Southampton to London Pipeline – written representation from Ashford Road, TW18

Southampton to London Pipeline Project

Application for a Development Consent Order – Reference EN070005

Ashford Road (TW18) Residents Group Written Representation, November 2019

Drawing number:
B2325300-JAC-000-CIV-DRG-005314

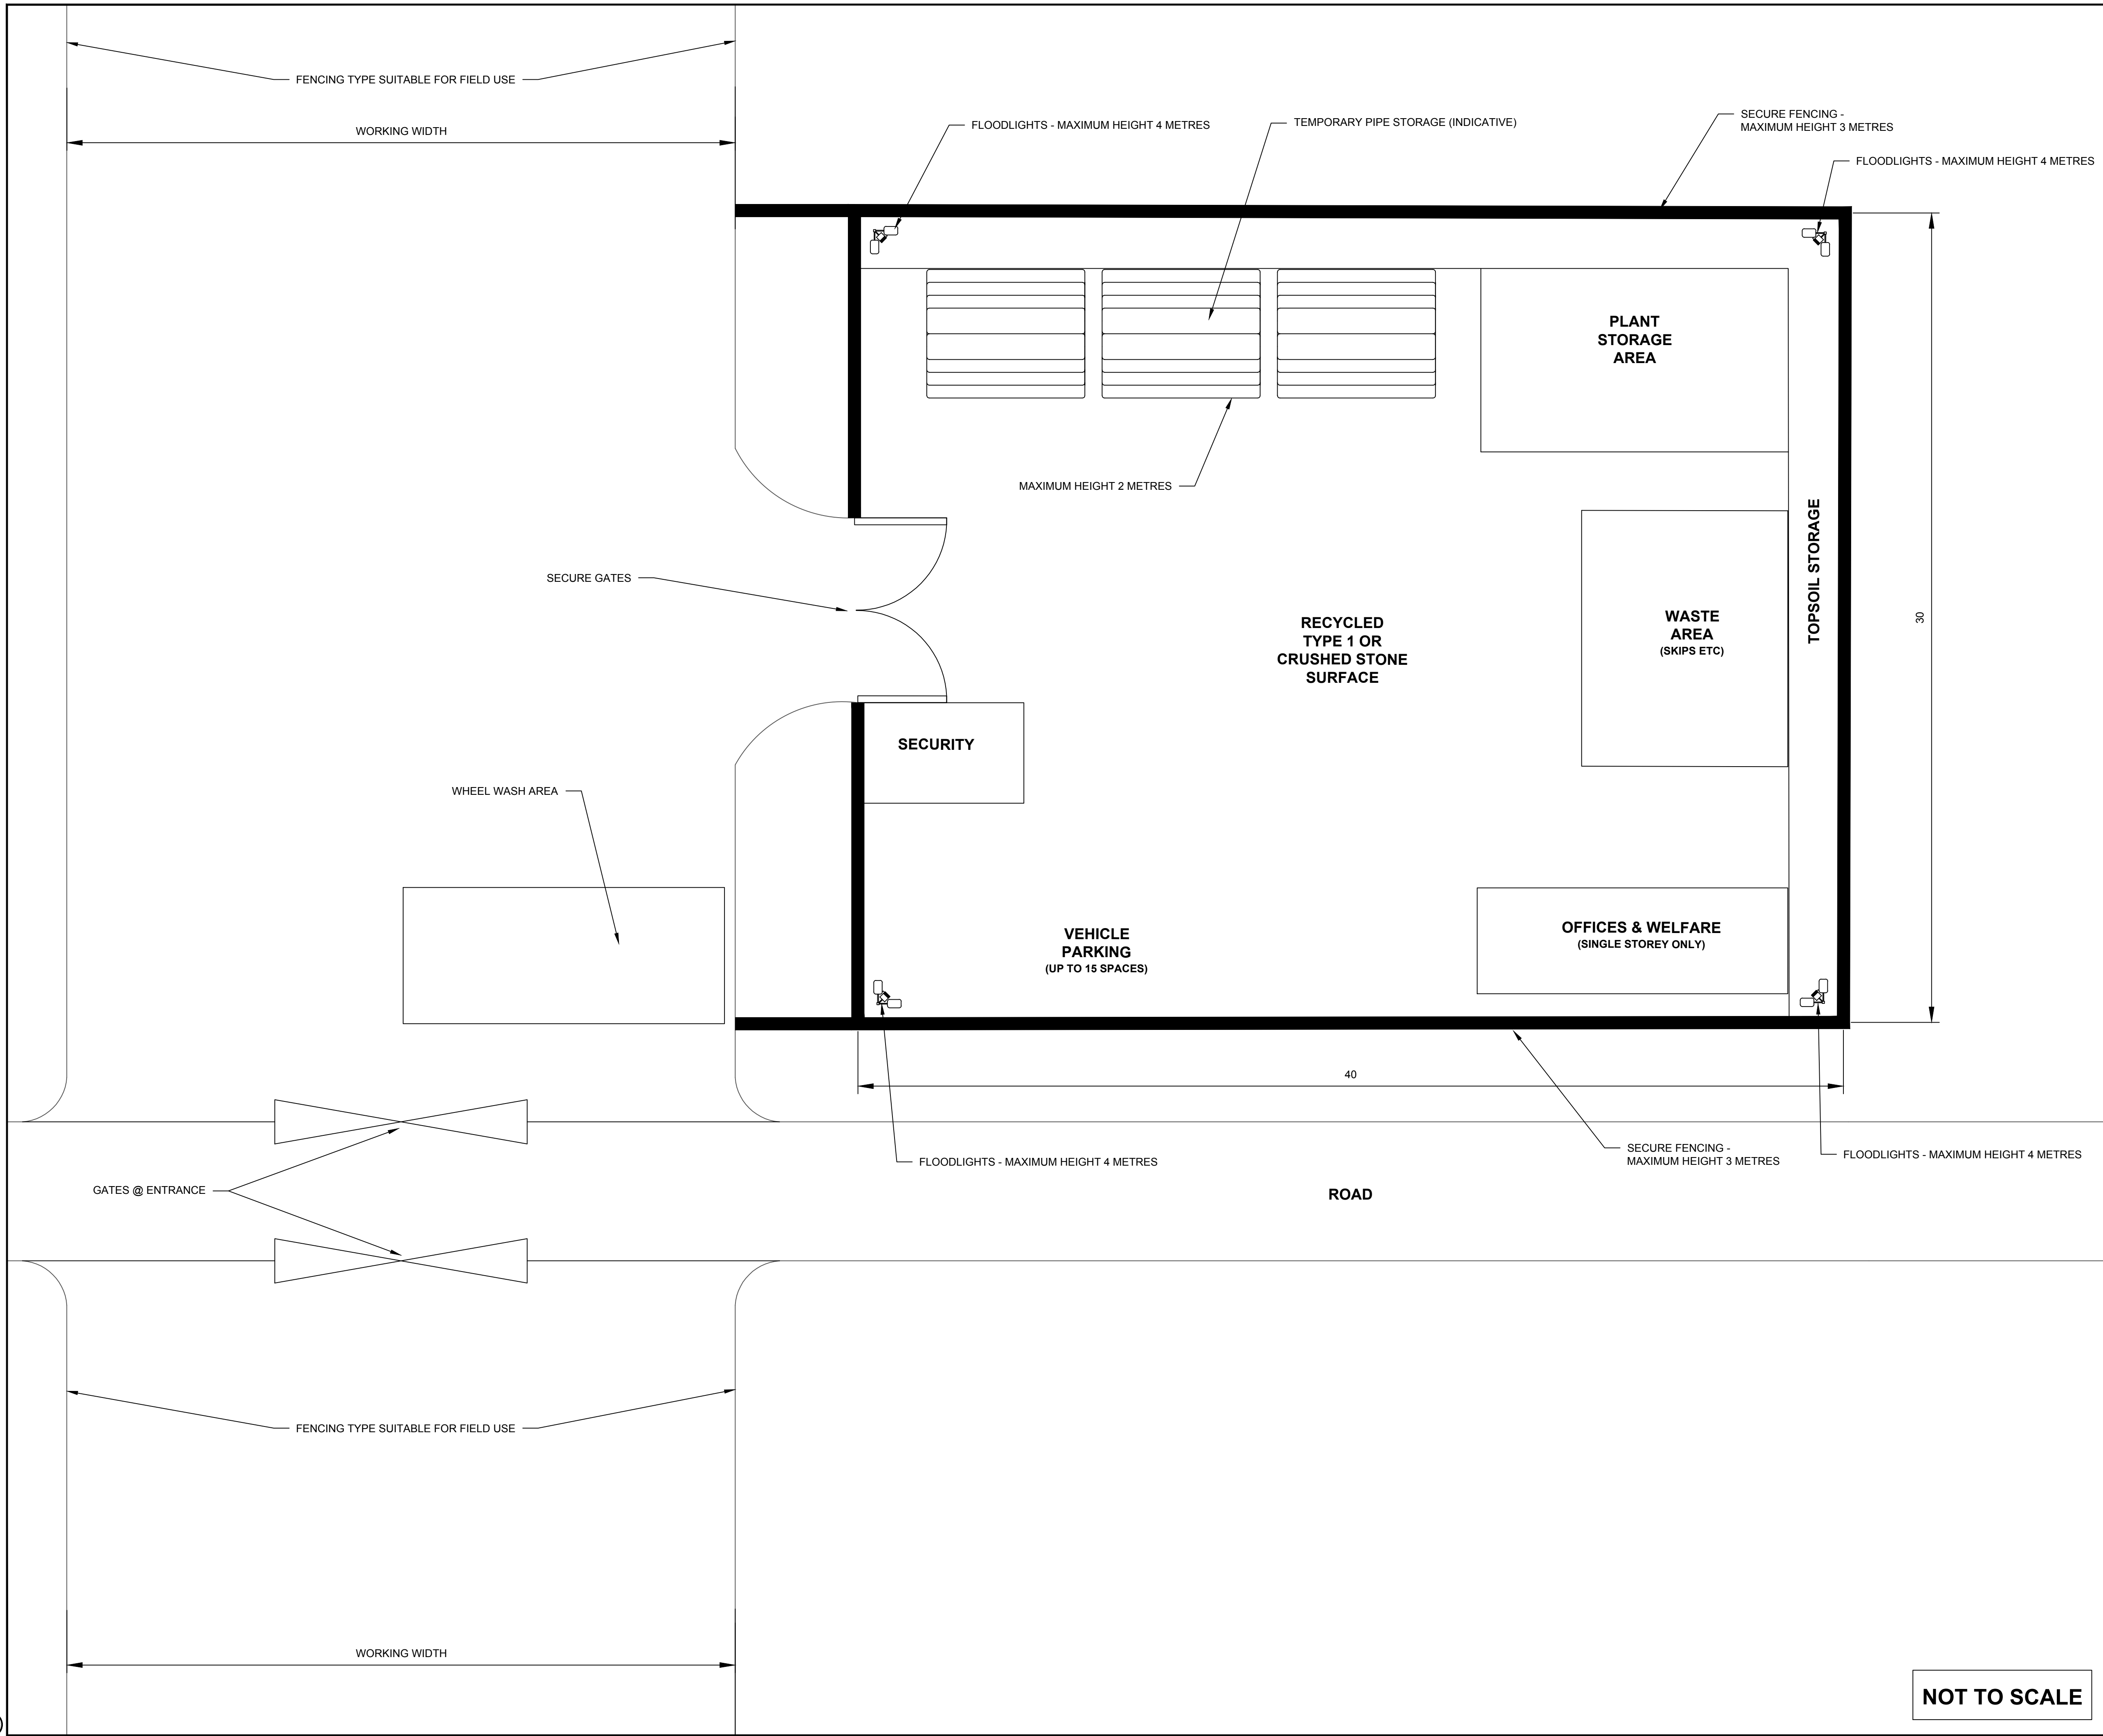
- Q25a.** How long will it take to install the temporary access?
- Q25b.** How many vehicles will this accomodate?
- Q25c.** Will the vehicles be contruction vehicles ie large items of plant
- Q25d.** What will be the operating hours?
- Q25e.** How will vehicles be controlled accessing and egressing the site – this is a very fast stretch of Ashford Road
- Q25f.** Will vehicless be required to cross over to the works location on the opposite side of the road – how will this be controlled?
- Q25g.** What are the environmental mitigation measures for EM70 and EM71?
